**WEST SUSSEX COUNTY COUNCIL
STRATEGIC PLANNING CONSULTATION**

SUBJECT: BR/311/17

**Aldwick Road, Aldwick Rest Home, 92-94 Aldwick Road, Bognor Regis
HMO**

1 PROPOSED GROUND FLOOR PLAN
1:100

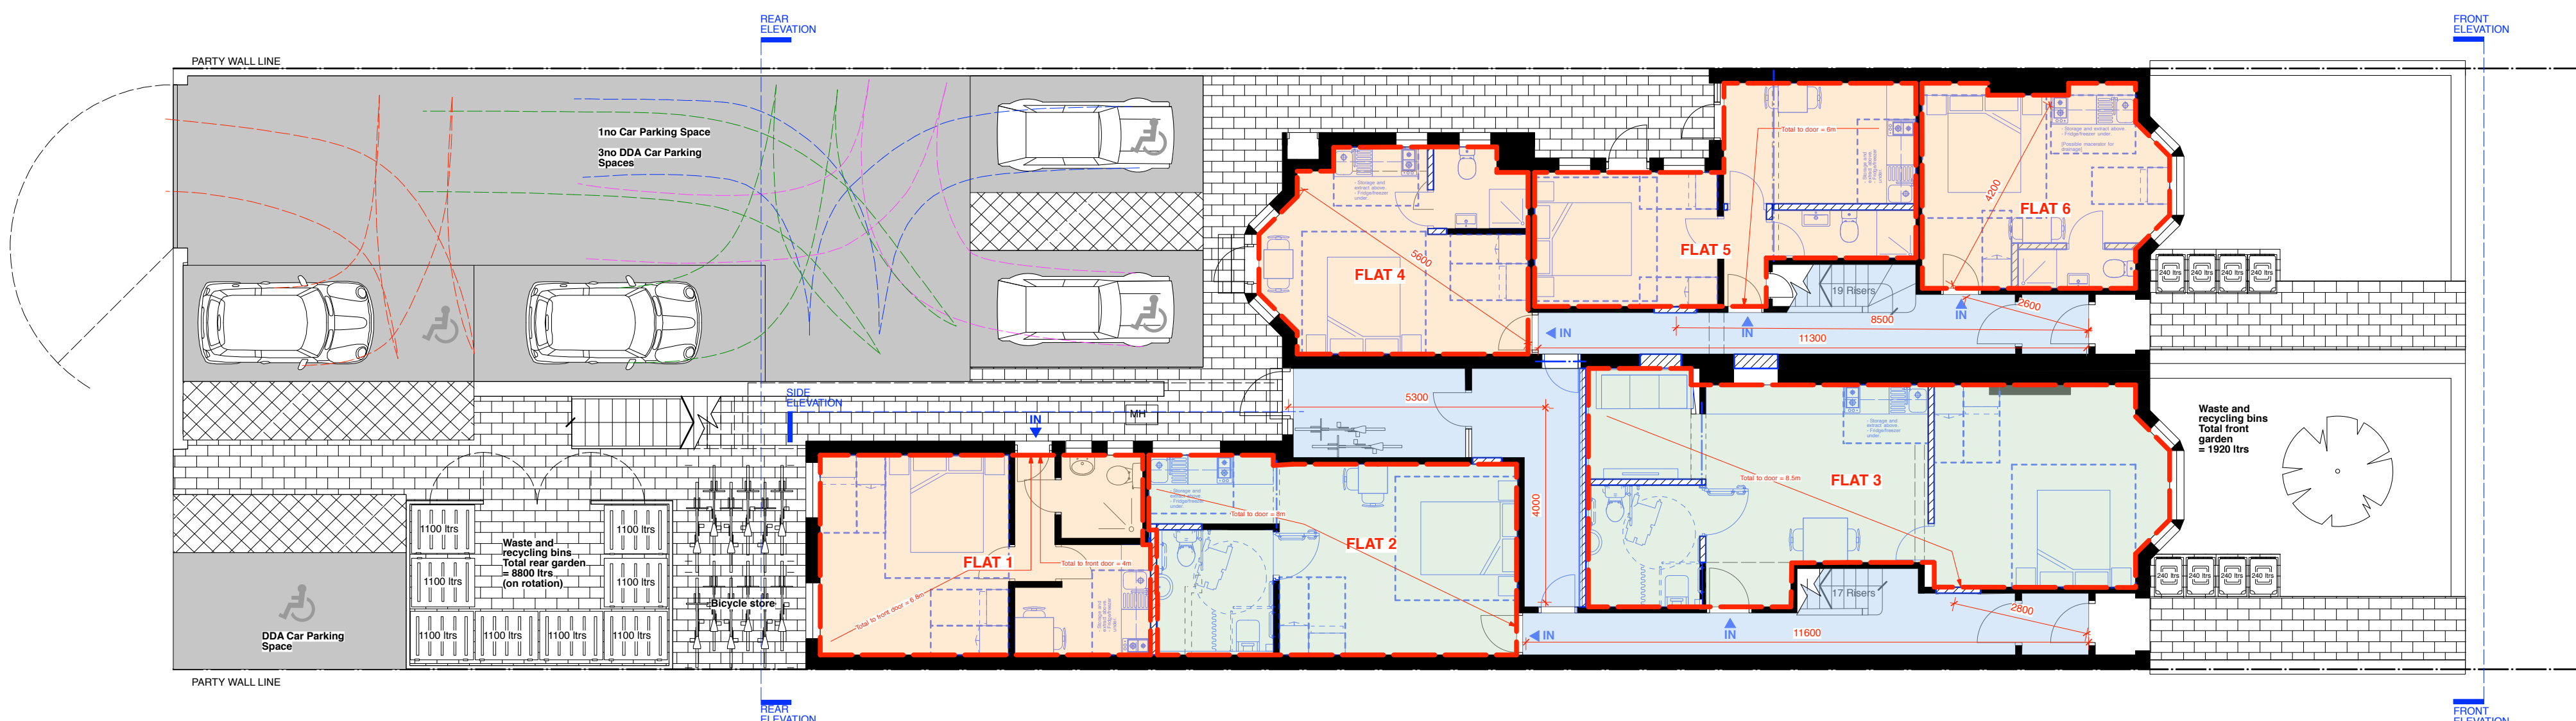
The proposal to change the use of the existing flats into a HMO to provide 16 flats for emergency housing use, has been considered by West Sussex County Council as the Local Highway Authority. The site will be renovated and will provide some car parking to the rear of the property. 5 spaces will be provided, of which four will be large enough for disabled use. This is lower than the recommended car parking standard of 0.5 spaces per flat (this would equate to 8 spaces) however given there is on-street parking close by this would be considered acceptable. The plans submitted show that there is scope for these cars to turn within the space provided safely.

The access to the rear of the flats is via a private driveway. The visibility from the private car park will be improved by the removal of the current wall and garage which will provide a better view of the access onto Nyewood Lane. This is a 30mph road residential through road and visibility here is considered sufficient, considering vehicles speeds in and out of the driveway will be low.

Cycle storage facilities will be provided to encourage sustainable transport options. This site is also considered to be in a sustainable location, in close proximity to local bus stops and a good walking distance to the main Bognor Train station.

Refuse collection would most likely continue from Nyewood Lane or on Aldwick Road, and a fire appliance would not need access to the rear of the property via the driveway.
